**WEST SUSSEX COUNTY COUNCIL
PLANNING SERVICES CONSULTATION**

SUBJECT: EP/128/17/HH - Widening of existing crossover (alteration to previous approval EP/164/16/HH).

59, North Lane, East Preston, BN16 1HN

Site Block Plan (1:500)

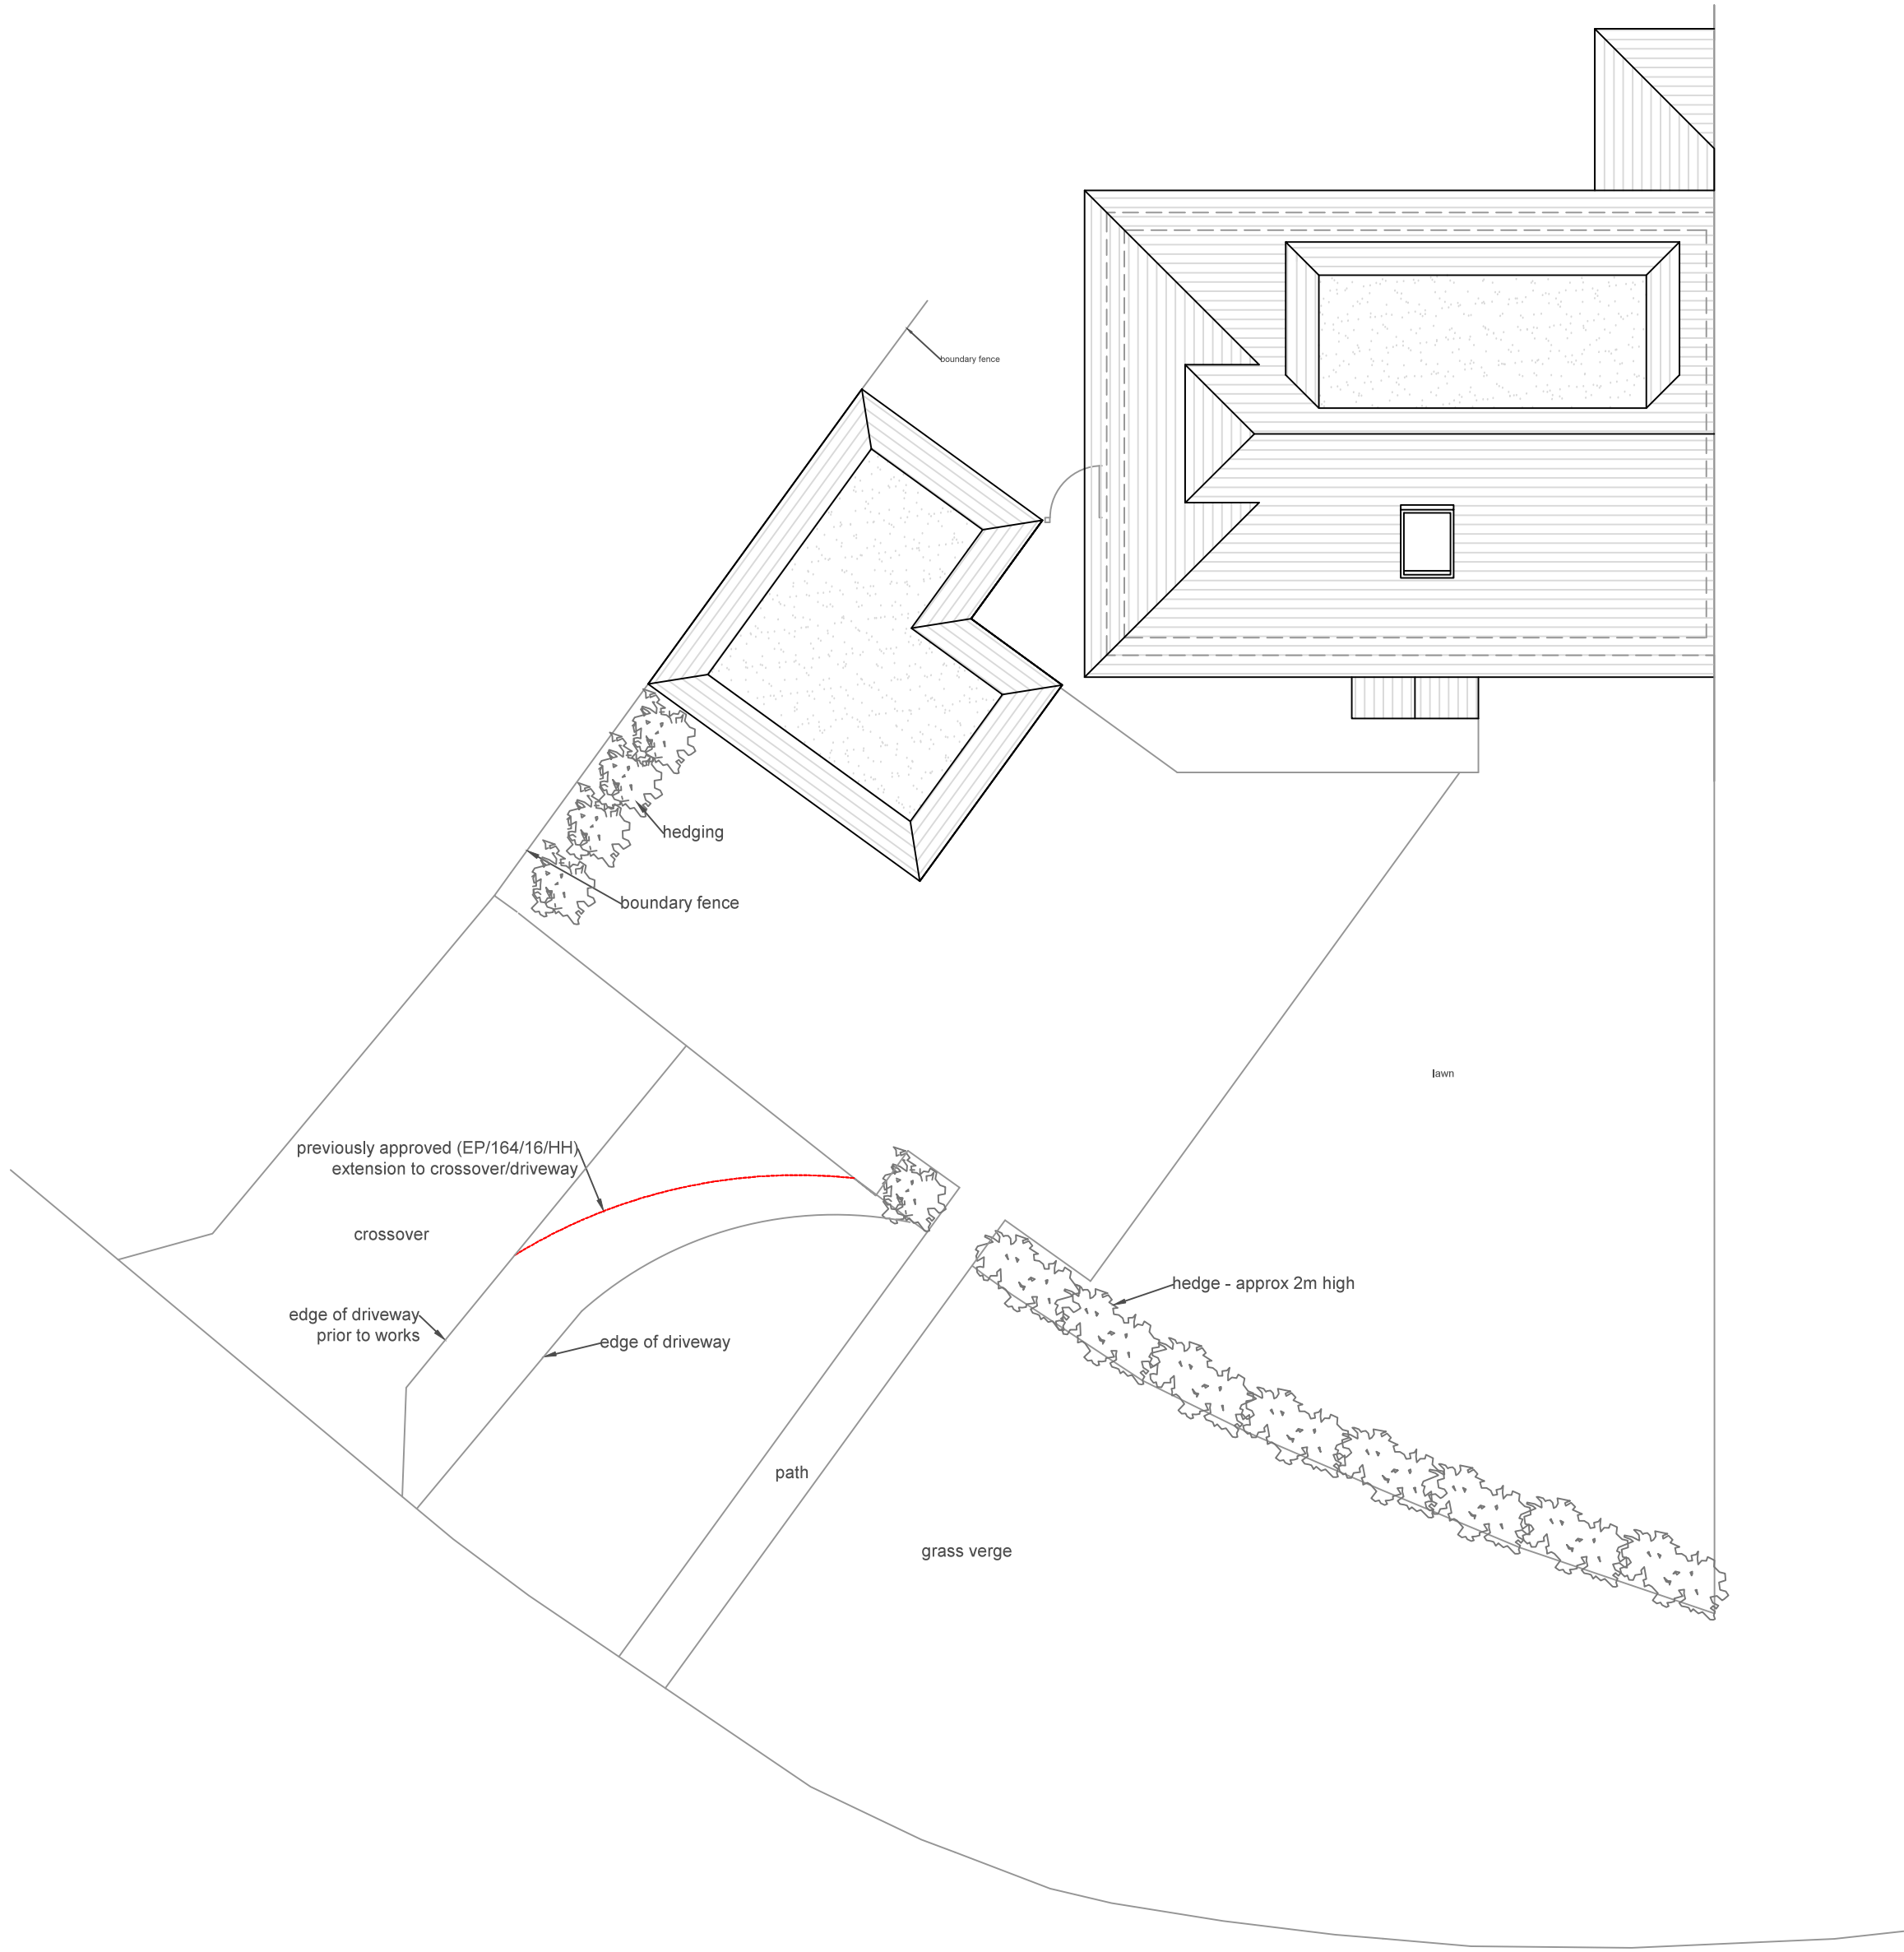
A study of the plan demonstrates that the widening of the access crosses land maintained by WSCC. The widening works must be implemented under licence to a specification obtained from WSCC Highways.

The applicant is advised to contact WSCC Highways (01243 642105 or <https://www.westsussex.gov.uk/roads-and-travel/highway-licences/dropped-kerbs-or-crossovers-for-driveways-licence/>) to obtain formal approval from the highway authority to carry out the access widening works on the public highway.
